KITTITAS COUNTY COMMUNITY DEVELOPMENT SERVICES

July 31, 2020

Subject: Dunford Large Lot Short Plat Final (SPF-20-00002) – Staff Review and Request for Additional Information

DUNFORD PRELIMINARY LARGE LOT SUBDIVISION

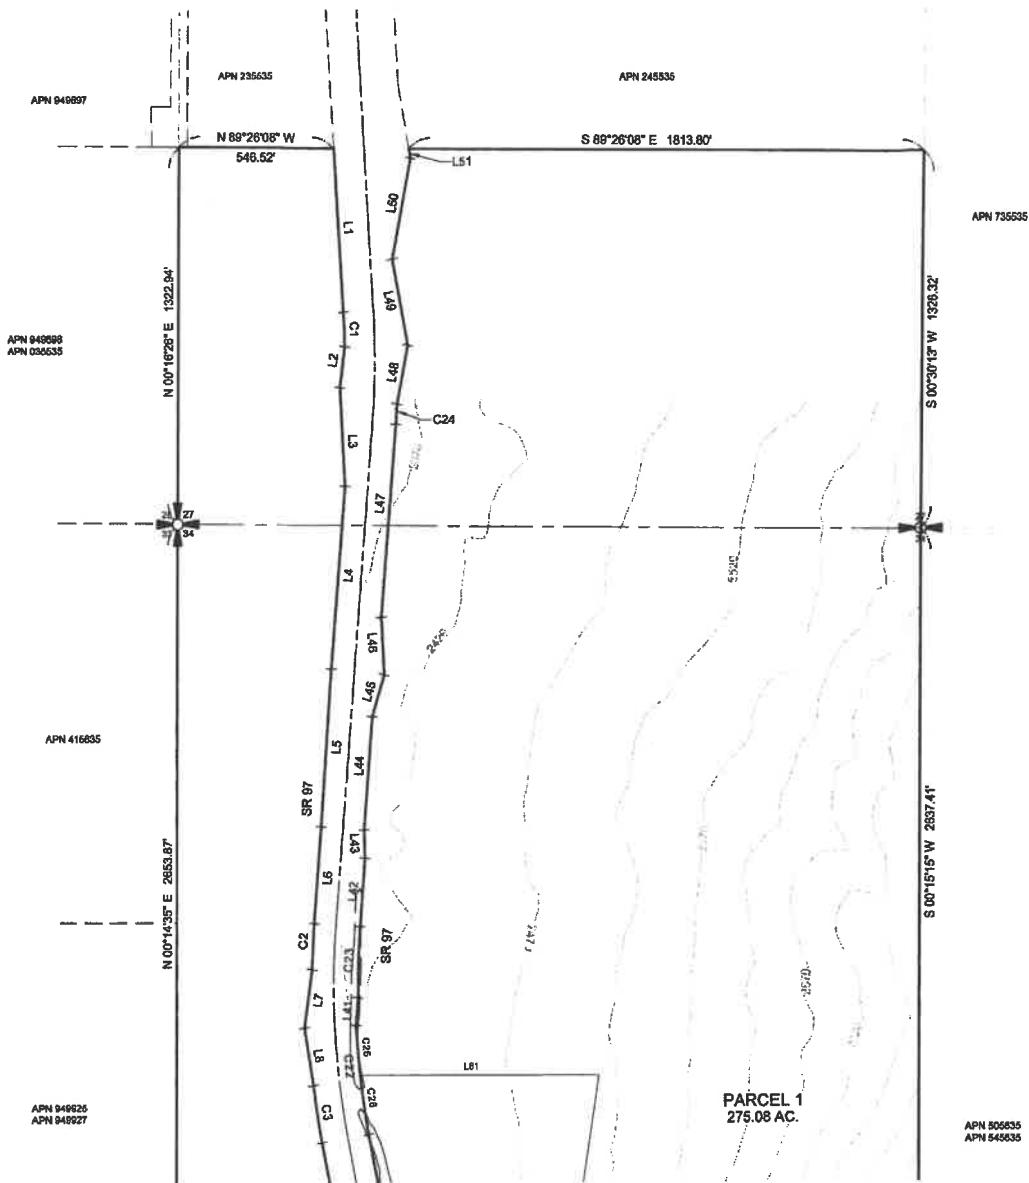
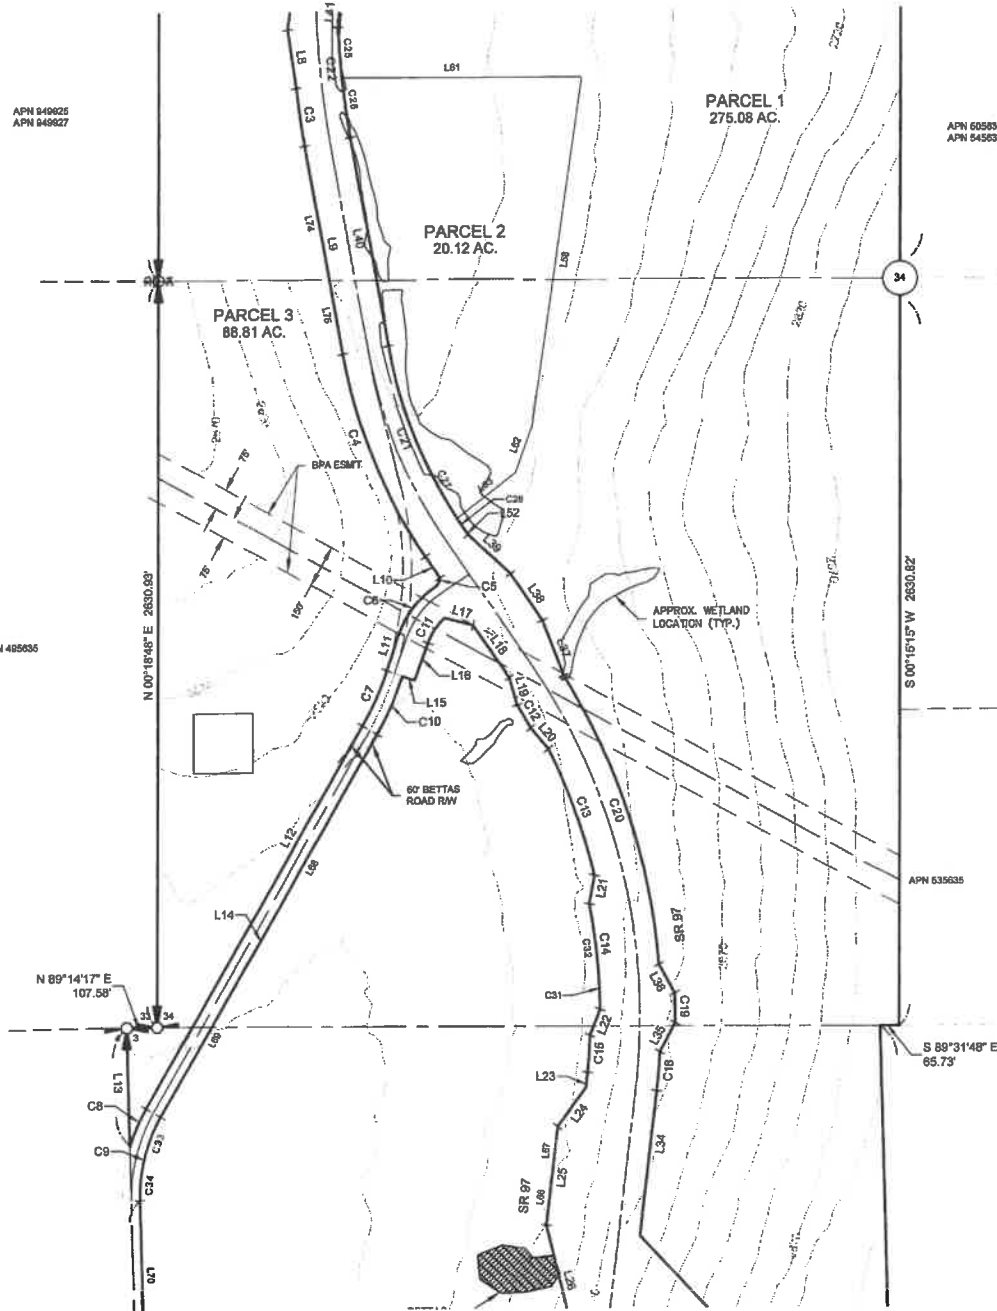
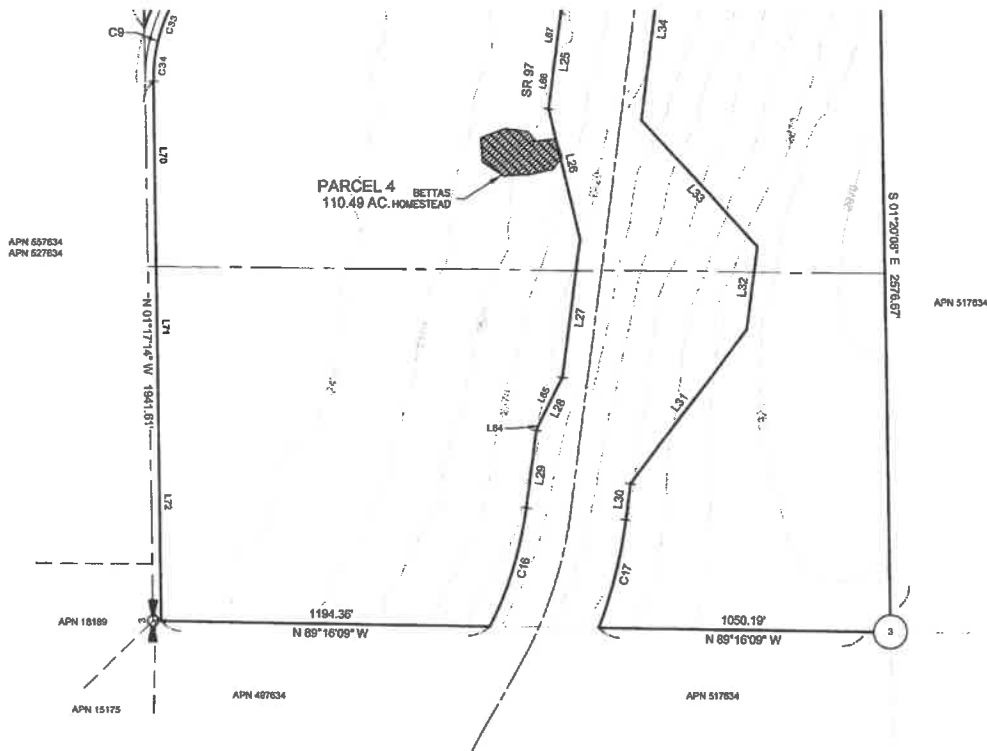
- The final short plat number "SPF-20-00002" shall also be present on the face of the plat and located directly above or below the LL-08-02 already shown.

- Wetlands A, B, C, and D and Stream "A" and their associated buffers shall be shown on the face of the final plat, as required by condition #4 of Ordinance 2010-013.

- The following plat notes shall be added as required by conditions #18 & 24h. of Ordinance 2010-013:
 - "Per RCW 17.10.140 Landowners are responsible for controlling and preventing the spread of noxious weeds, accordingly, the Kittitas County Noxious Weed Board recommends immediate reseeding of areas disturbed by development to preclude the proliferation of noxious weeds."

- "Kittitas County will not accept private roads for maintenance as public streets or roads until such streets or roads are brought into conformance with current County Road Standards. This requirement will include the hard surface paving of any street or road surfaced originally with gravel."

- All open space tracts shall be identified on the final plat.
- The final plat map shall show the locations of any applicable well head protection zones.
